STATE OF WASHINGTON
DEPARTMENT OF ECOLOGY

March 26, 2015

Re: CU-14-00004

Thank you for the opportunity to comment during the optional determination of nonsignificance process for the small scale event facility conducting more than 8 events a year on approximately 50 acres, proposed by Scott & Gayle McIntosh We have reviewed the documents and have the following comments.

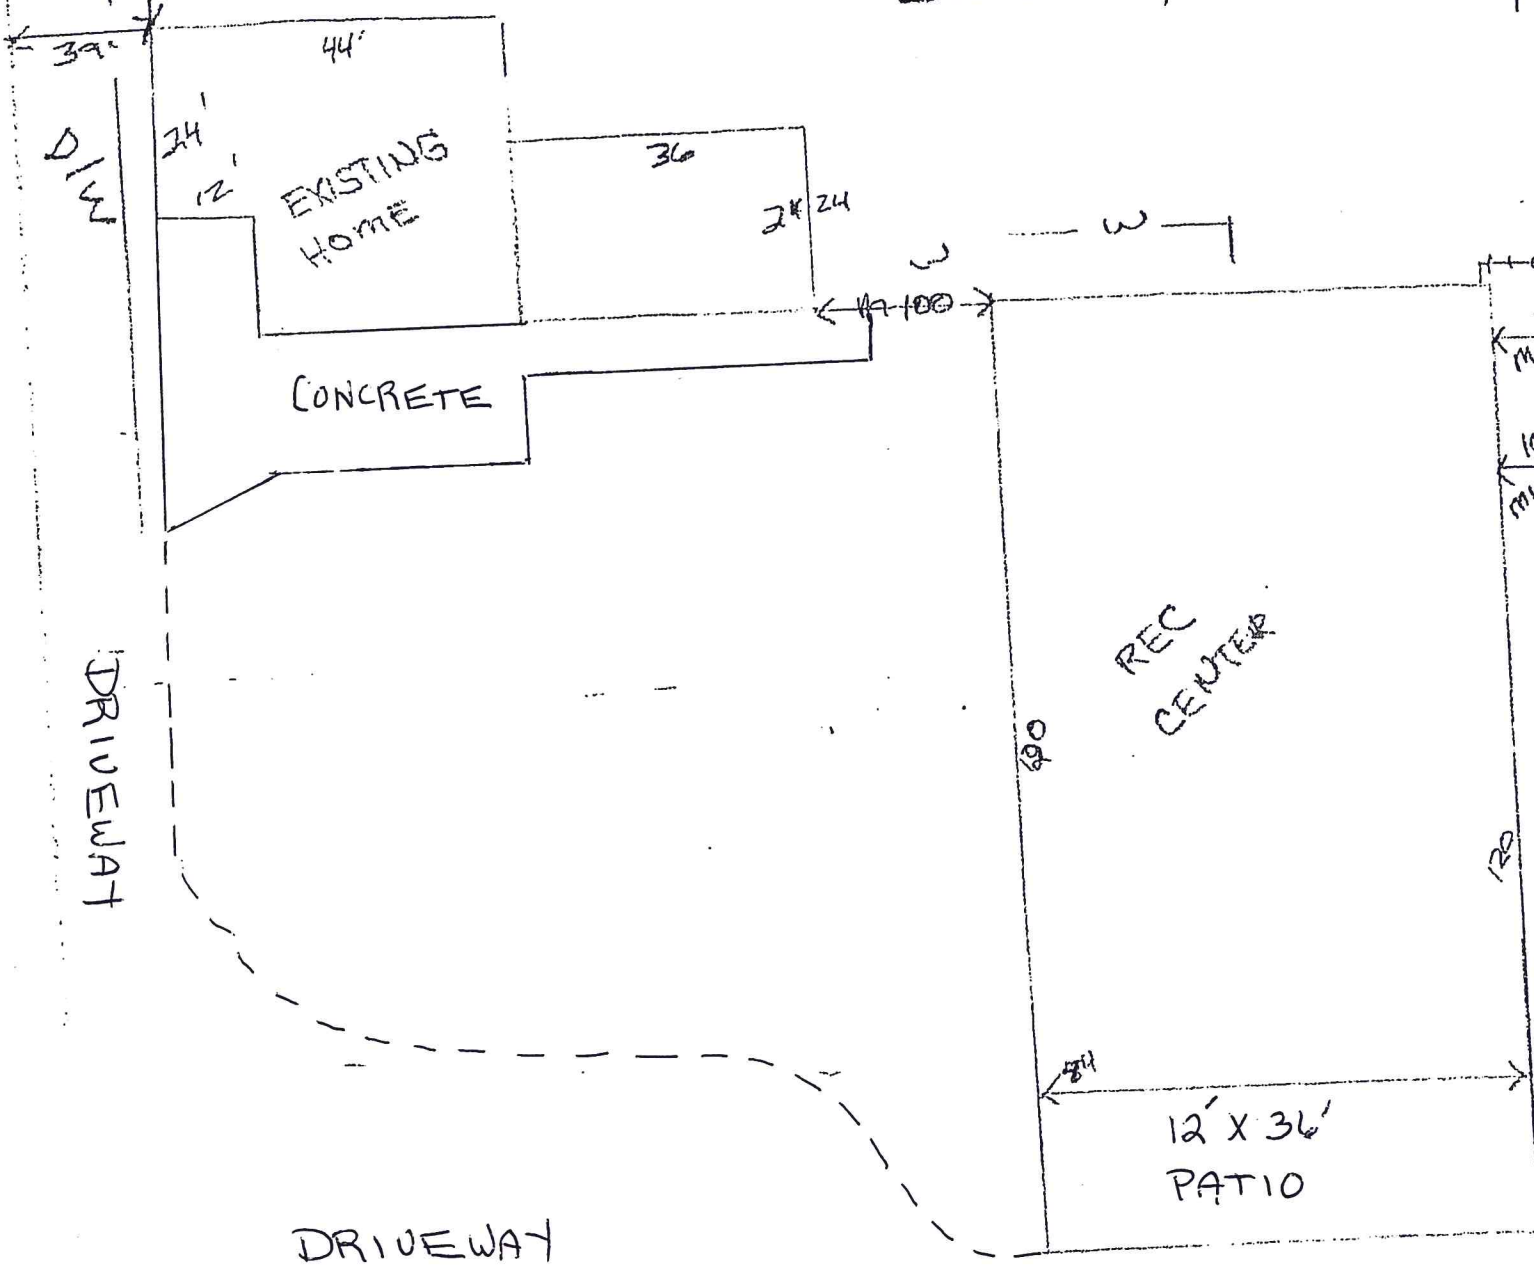
All water wells constructed shall be in accordance with the provisions of Chapter 173-160 WAC by a driller licensed in the State of Washington. All wells must be located a minimum of 100 feet from any known, suspected, or potential source of contamination and shall not be located within 1,000 feet of the property boundary of solid waste

National Wetland Inventory Maps and information within exhibit A (attachment to the SEPA checklist) show and list the presence of extensive wetlands on the property. (See map below from Ecology's GWIS database) These wetlands are associated with and adjacent to the 100-year floodplain of Dry Creek. The wetlands provide important water quality improvement and flood retention, as well as some habitat functions. Any kind of structural improvements or fill should be placed so as to maintain adequate buffers around these on-site wetlands. Parking areas, stormwater treatment, and other developments should be placed outside of wetlands and their buffer areas.

The actual location of wetlands on site should be determined by a wetland delineation before additional development occurs. (NWI maps are sometimes not perfectly justified in aerial photo base maps, and do not show smaller wetlands due to the resolution capability of aerial photo interpretation.) Wetland delineations typically have a "shelf life" of approximately 5 years from the date of the original data collection. This is due to the fluctuating nature of wetland boundaries over time, and potential shifts in the location of Dry Creek and its active channel throughout the floodplain.

Passive use of the site as a small event center is a potentially good match with protection of wetland and riparian resources as long as drainfields, parking lot surfaces and stormwater is adequately treated before it would flow into a wetland area. Protection and further voluntary enhancement of the riparian and wetland vegetation areas would increase the desirability of this location for the proposed use. Ecology wetland staff would be happy to provide guidance on what kinds of native plants could be successfully planted on site to enhance the wetlands and buffer areas. Please call Catherine Reed at (509) 575-2616 for assistance.
